Meeting note

Project name	Northampton Gateway Rail Freight Interchange
File reference	TR050006
Status	Final
Author	The Planning Inspectorate
Date	10 April 2018
Meeting with	Northampton Gateway Rail Freight Interchange
Venue	Teleconference
Attendees	The Planning Inspectorate Kathryn Dunne – Infrastructure Planning Lead Kate Mignano – Case Manager Emre Williams – Case Manager Dean Alford – Case Officer The Applicant Morag Thomson - Eversheds Sutherland Laura-Beth Hutton- Eversheds Sutherland
Meeting objectives	To provide feedback on latest iteration of draft Land Plans, Works Plans and the Rail Phasing Plan
Circulation	All attendees

Advice in the form of written comments by the Inspectorate is attached to this meeting note as Appendix A (Northampton Gateway RFI: Comments on the draft Land Plans, Works Plans and the Rail Phasing Plan). The discussion noted the feedback issued by the Inspectorate to the Applicant held in Appendix A on the draft plans referenced above and therefore these documents should be read in conjunction.

Drawing Title		WORKS PLANS KEY PLAN	
Scale	1:15,000	Drawn	P. Goodyear
Size	A1	Reviewed	S. Hilditch
Regulation	5(2) (j)	Document	2.2
Drawing Status		SUBMISSION	
Drawing No.		Revision	
NGW-BWB-LSI-XX-DR-C-00160		P12

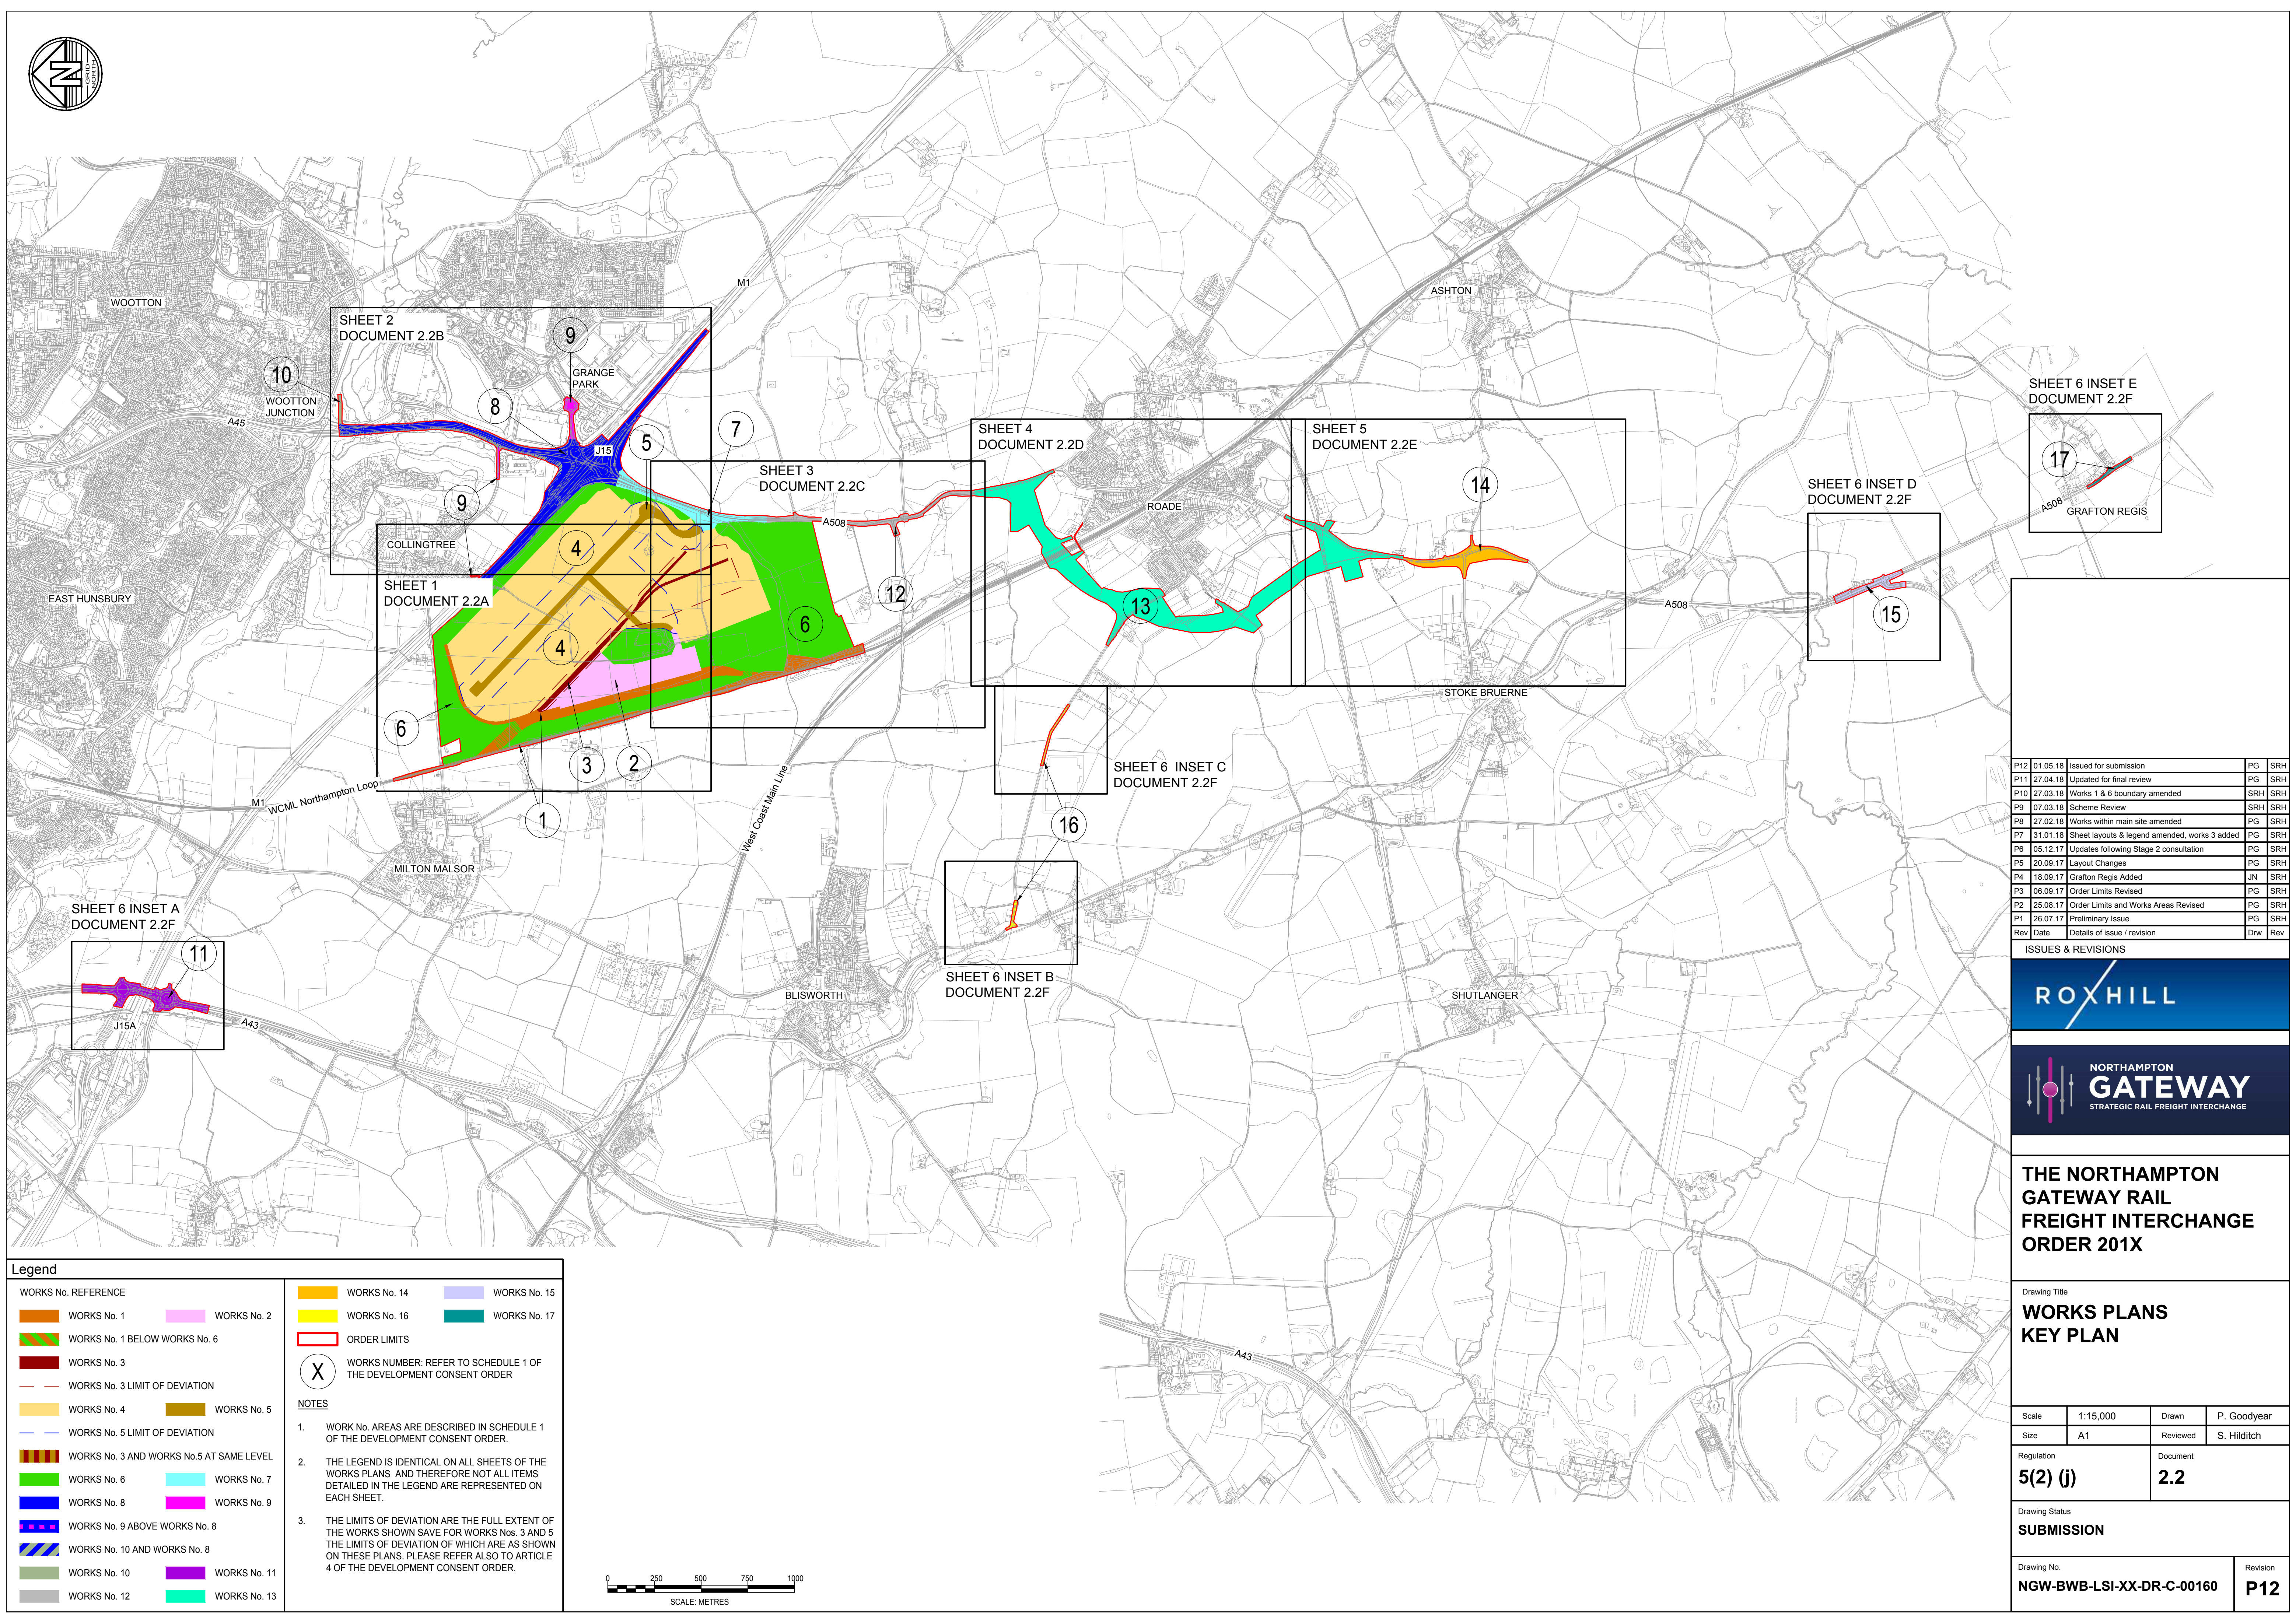
The Inspectorate asked for clarification on the Limits of Deviation (LoD) as described on the Works Plans, in particular the 20 metre LoD description and whether the LoD are inclusive or exclusive of the individual works, as drawn on the plans.

The Inspectorate advised that it would be useful to show the detail of the proposed layout as a separate layer on the Works Plans. The Applicant stated that by illustrating the proposed layout as suggested, this could be misleading; however, the Applicant confirmed that they will cross-reference this into the dDCO, possibly under the general arrangement plans in the works, and this detail will be secured through the protective provisions. This approach will also be clarified within the Explanatory Memorandum (EM).

The Applicant confirmed that the LoD wouldn't include works outside of the red line boundary; however, the way the LoD are explained on the plans will be reviewed.
